CITY OF ALBUQUERQUE

**Re: Aloha Tanning, 420 San Mateo Blvd., Traffic Circulation Layout
Architect's Stamp dated 10-31-10 (K18-D028)**

Based upon the information provided in your submittal received 12-08-10, the above referenced plan cannot be approved for Building Permit until the following comments are addressed:

Parking Calculations
 Vicinity Map
 Legal Desc.
 Aerial Photo indicates access is shared w/ adjacent lots
 - show how this is accomplished
 (need to show at least part of adj. lots)
 - provide copy of access easement

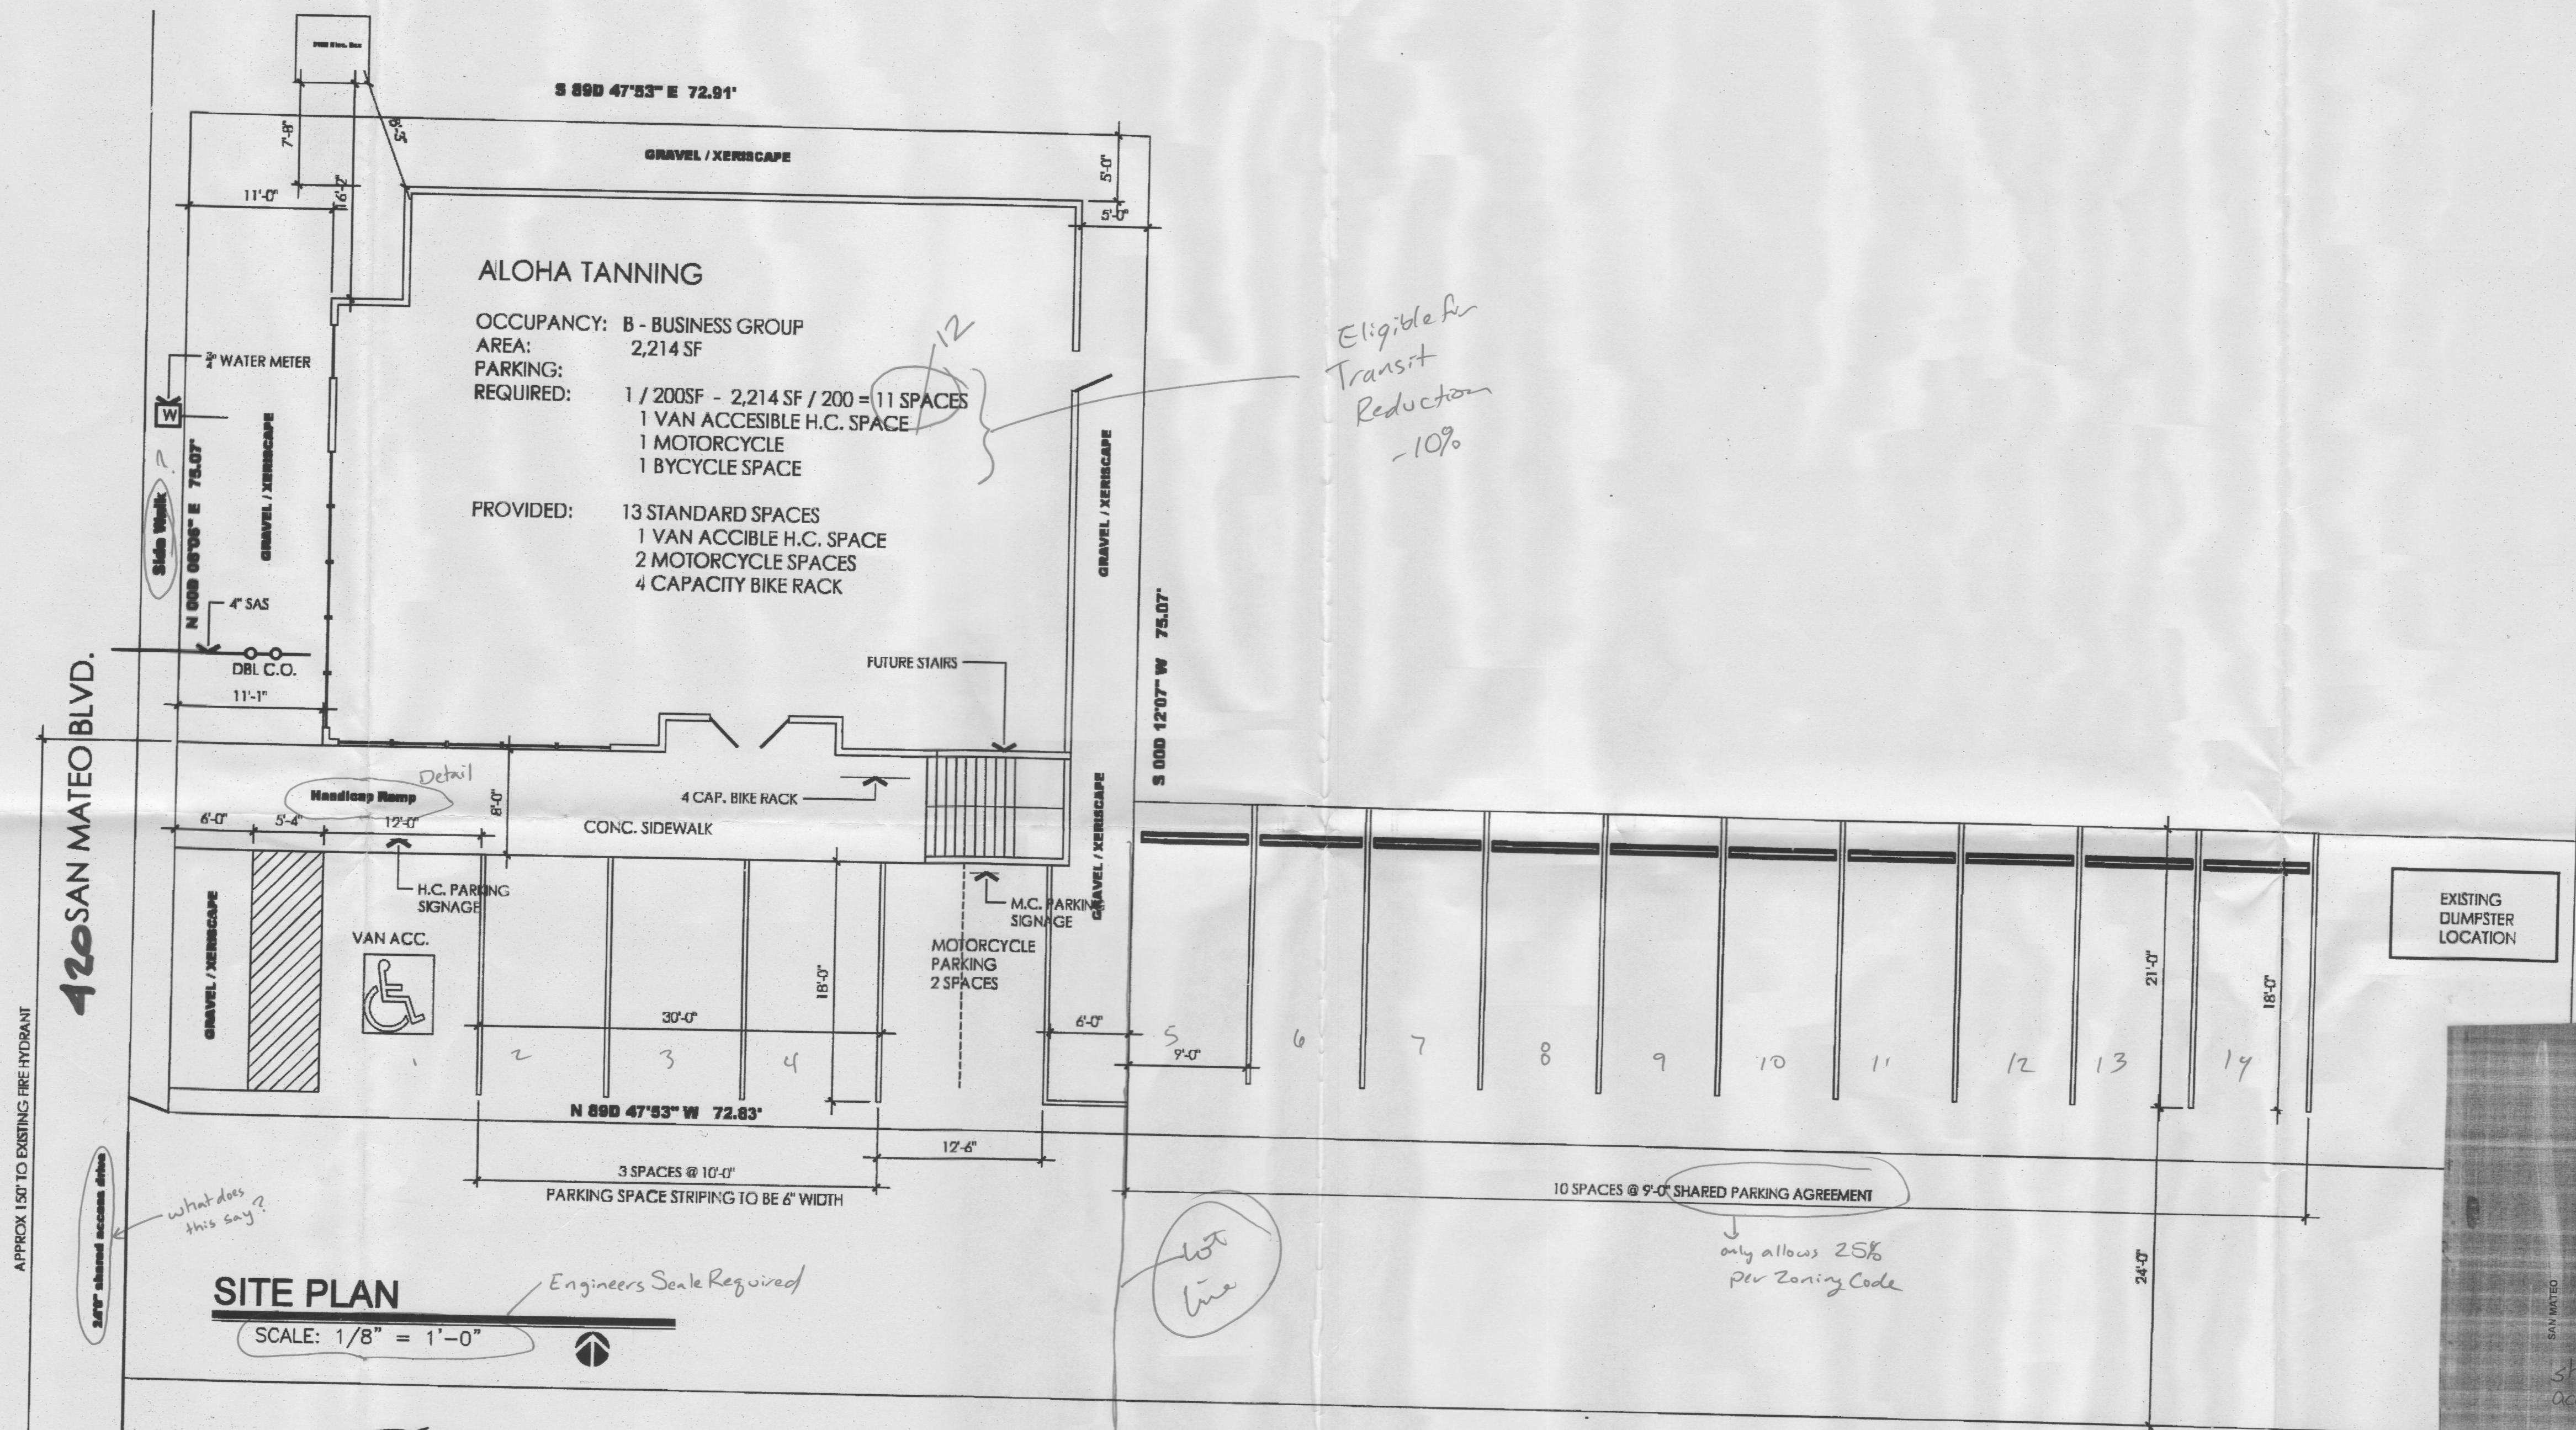
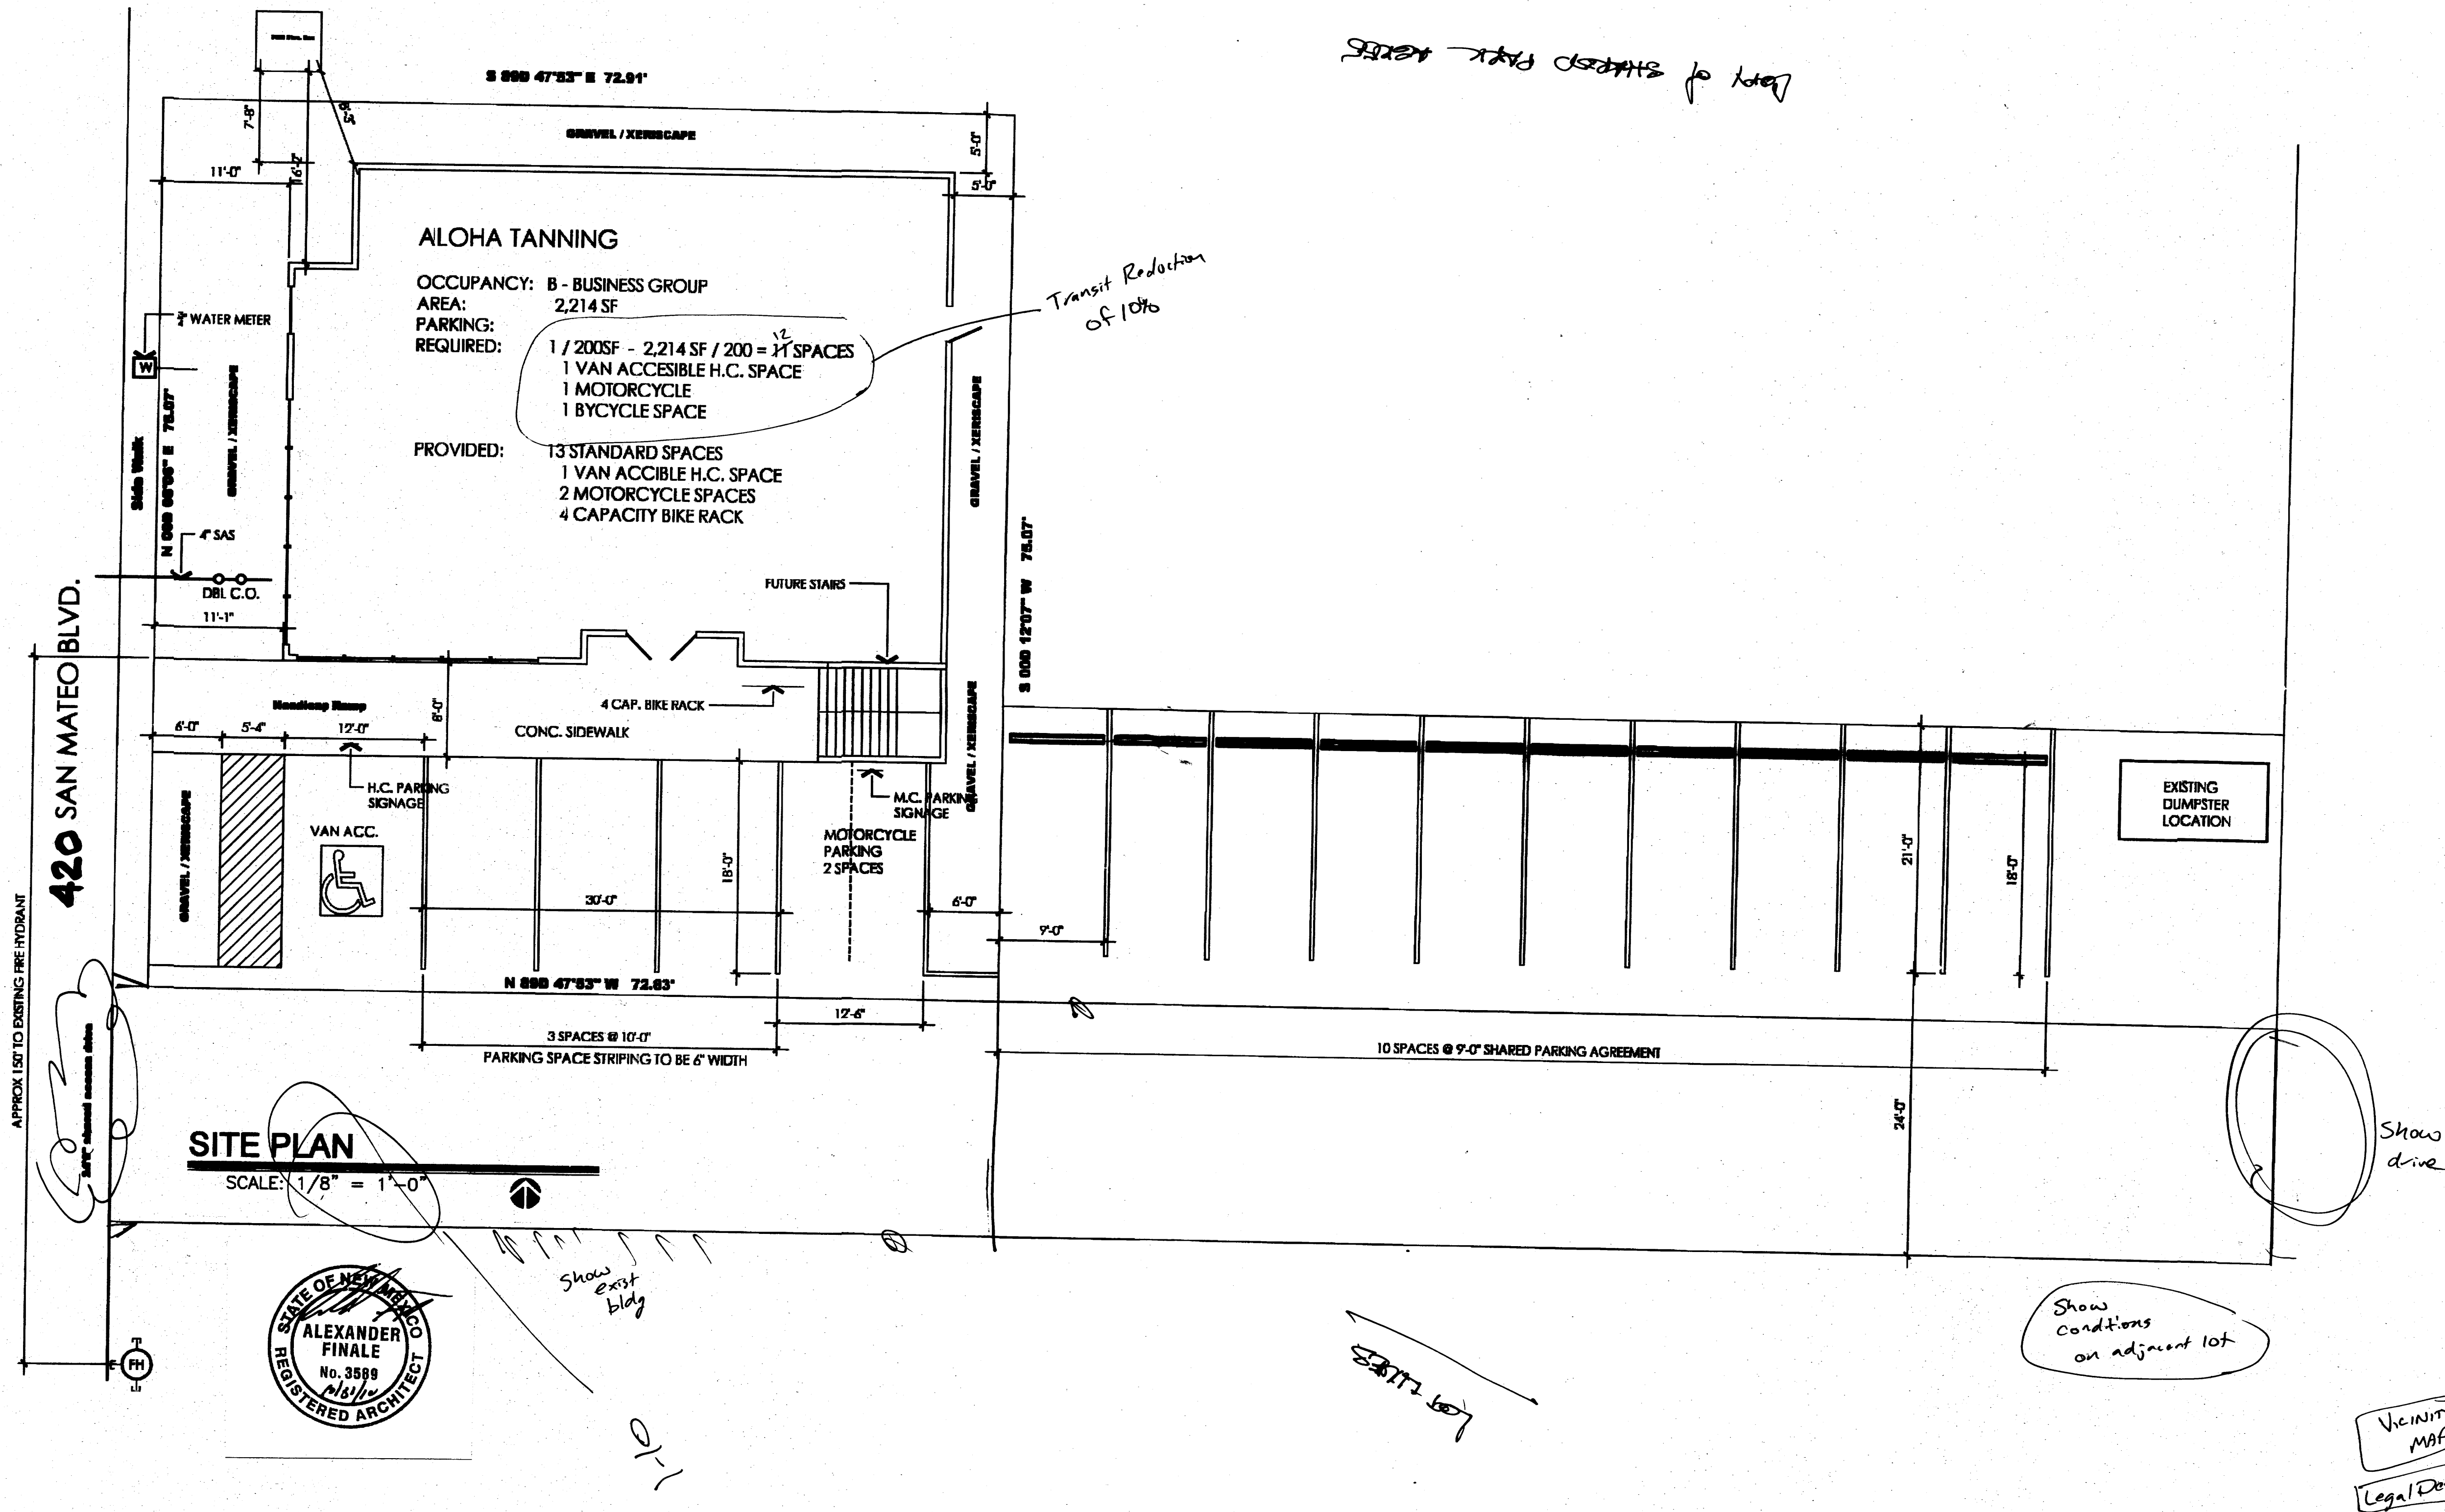
1. A portion of the text on the plan is illegible; please revise.
2. Please show a vicinity map.
3. Clearly show all lot lines on the plan.
4. Recent aerial photography indicates access to this site is shared with adjacent lots. The plan must be revised to show all shared access, including access on other lots. Provide a copy of the shared access easement.

5. It appears that the number of parking spaces required should be 12, not 11. Please check the calculations.
6. The legal description must be included on the plan.

7. Ten of the parking spaces shown for this site appear to be located on the adjacent lot. A shared parking agreement is referenced on the plan. However, the *City of Albuquerque Comprehensive Zoning Code*, Chapter 14, Article 16, Part 3, Section 1(E)(6)(c) specifies, "The total maximum reduction for transit and shared parking shall not exceed 25%." The current layout shows less than 40% of the required parking located on site. The layout as shown is not acceptable.

8. Please show the location of the nearest driveway on the adjacent lot.
9. Define width of all sidewalk, existing and proposed.
10. List the width of the existing drivepad.

11. Clearly show the 6-foot wide, ADA accessible pathway from the roadway to the building. Show all ramps and provide details (define the maximum slope).

12. Since San Mateo Boulevard is an arterial roadway, driveways with right in / right out only have a minimum driveway width of 30 feet (see the *Development Process Manual*, Chapter 23, Section 6, Part B.8).

13. Per the Development Process Manual, Chapter 27, Section 2, Part B.1, only the following scales may be used:

- 1" = 50'
- 1" = 40'
- 1" = 20'
- 1" = 10'
- 1" = 100' (for overall layouts only)

14. Clearly show the 6-foot wide, ADA accessible pathway from the handicapped parking spaces to the building. Show all ramps and provide details (define the maximum slope).
